WEST SUSSEX COUNTY COUNCIL CONSULTATION

TO:	Arun District Council FAO: Harry Chalk
FROM:	Highways, WSCC
DATE:	12/11/2025
LOCATION:	Byfields, Nyton Road, Westergate, PO20 3US
SUBJECT:	AL/113/25/DOC Construction of 1 No. 3 bed dwelling. AL/40/21/PL Conditions(s) Condition 4 - Installation of covered and secure cycle storage Condition 5 - Installation of EV charging.
DATE OF SITE VISIT:	N/A
RECOMMENDATION:	Advice
S106 CONTRIBUTION TOTAL:	N/A

This application seeks the approval of details reserved by Conditions 4 and 5 of approved application AL/40/21/PL (*Construction of 1 No. 3 bed dwelling*). WSCC in its role as Local Highway Authority (LHA) was a consultee for application AL/40/21/PL, raising no highway safety or capacity concerns.

Revision:			
address		Byfields, Nyton Road, PO20 3US	
project		Proposed new dwelling	
title		EV charging point and cycle storage.	
scale	date	dwg no.	revision
As noted @ A3	November 2025	2022.352.Cond

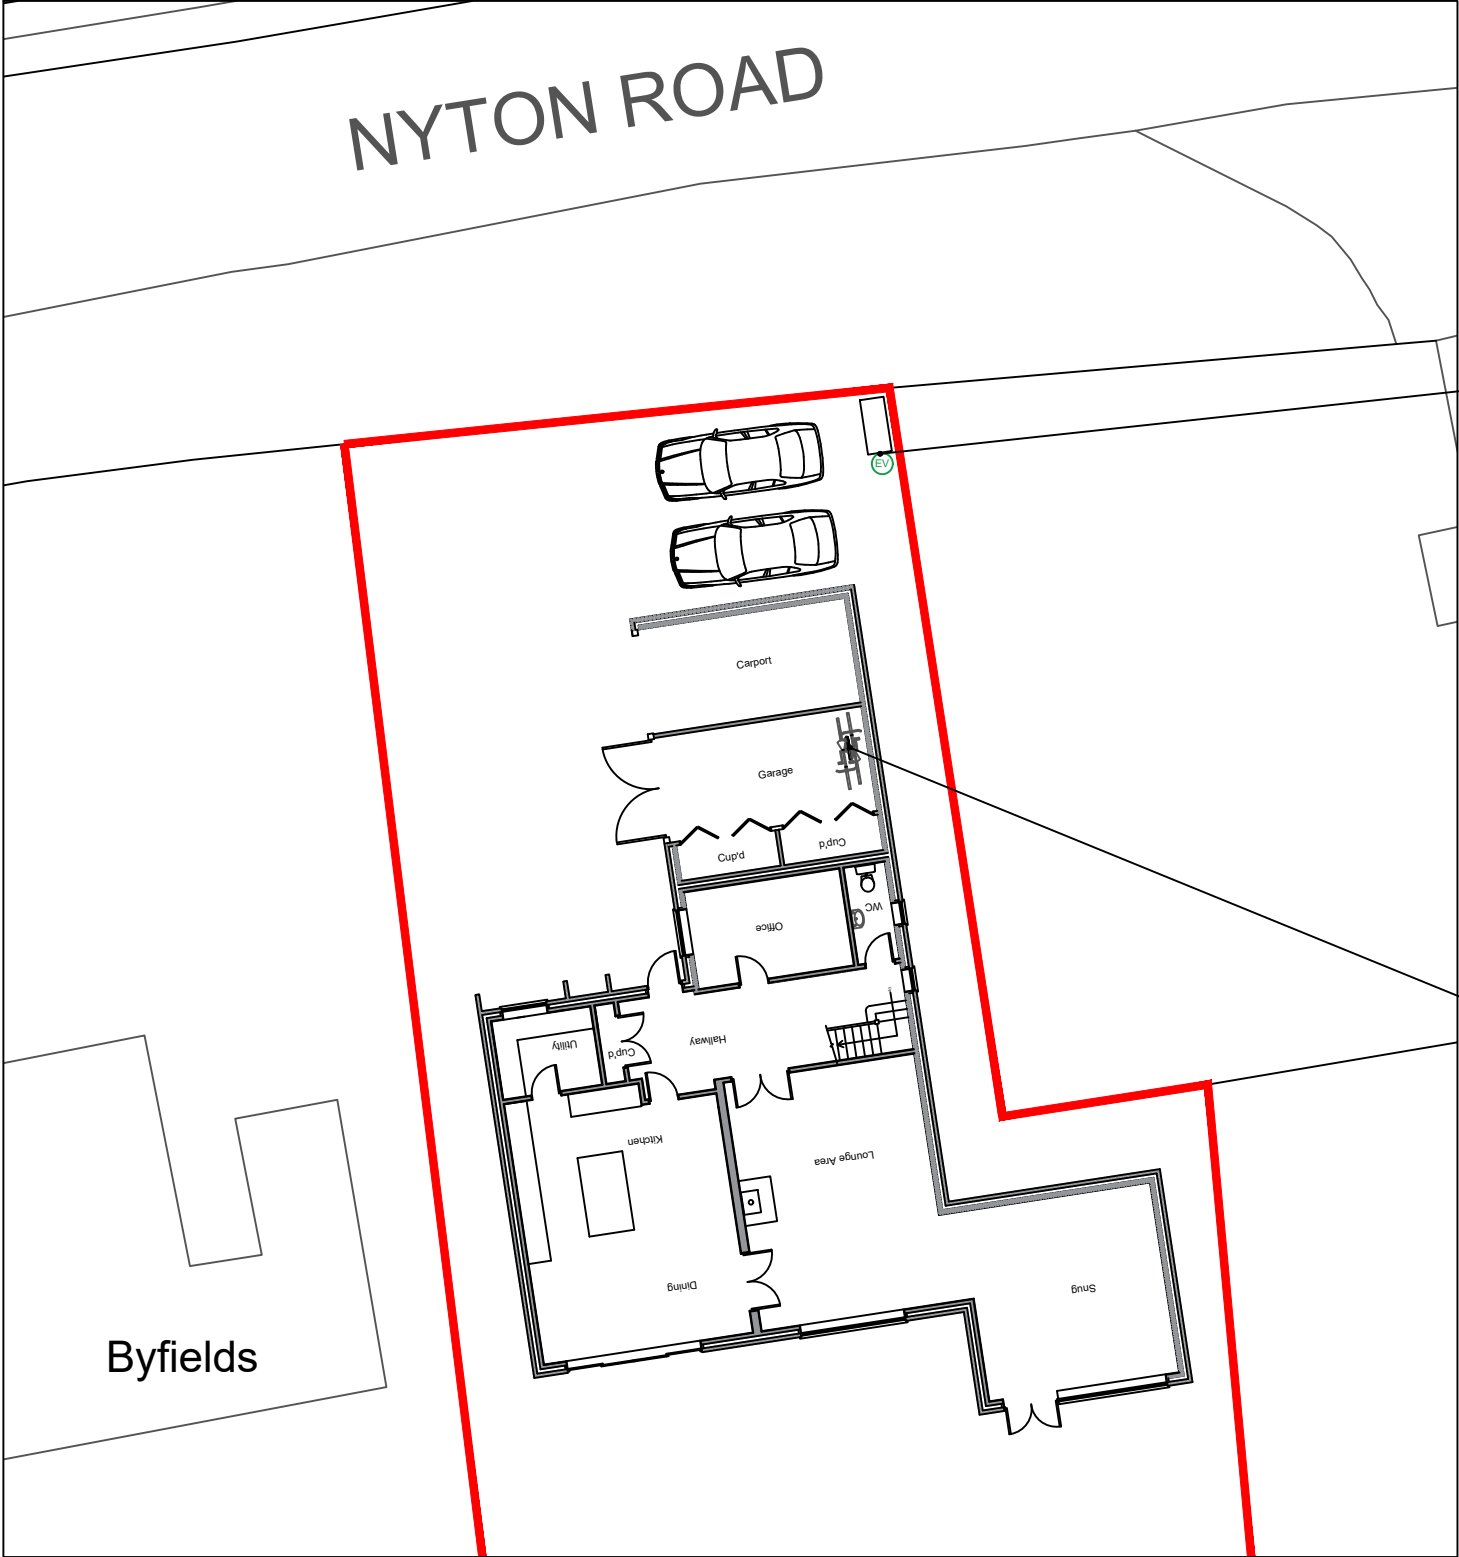
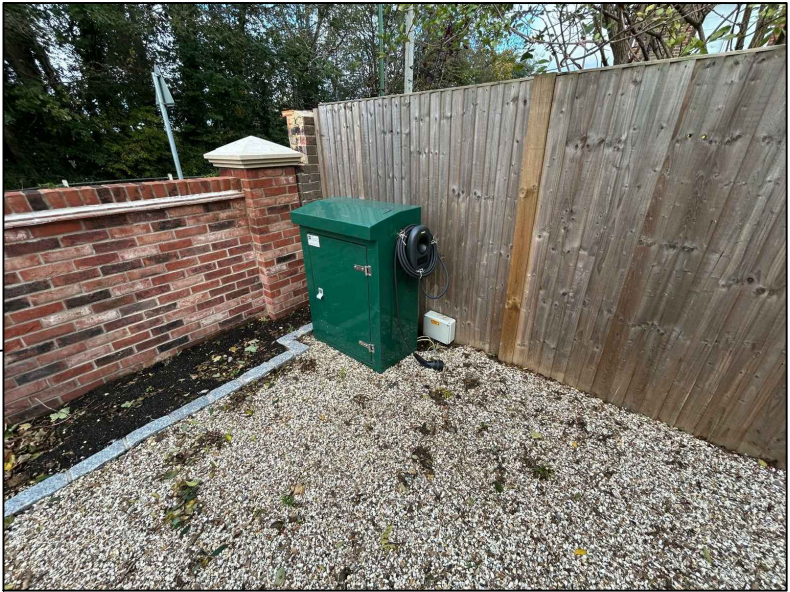
The applicant has submitted a plan (2022.352.Cond) demonstrating the provision of a cycle storage hoop located within the proposed garage. Considering the available car parking space available outside of the garage (two car parking spaces, one carport), I am minded to accept the use of the garage, which does not meet MfS specifications, for cycle storage.

The applicant has submitted a plan (2022.352.Cond) demonstrating the location of an EV charging point to serve the proposed car parking spaces.

The LHA are satisfied with the details provided in regards to Condition 4.

The LHA are satisfied with the details provided in regards to Condition 5.
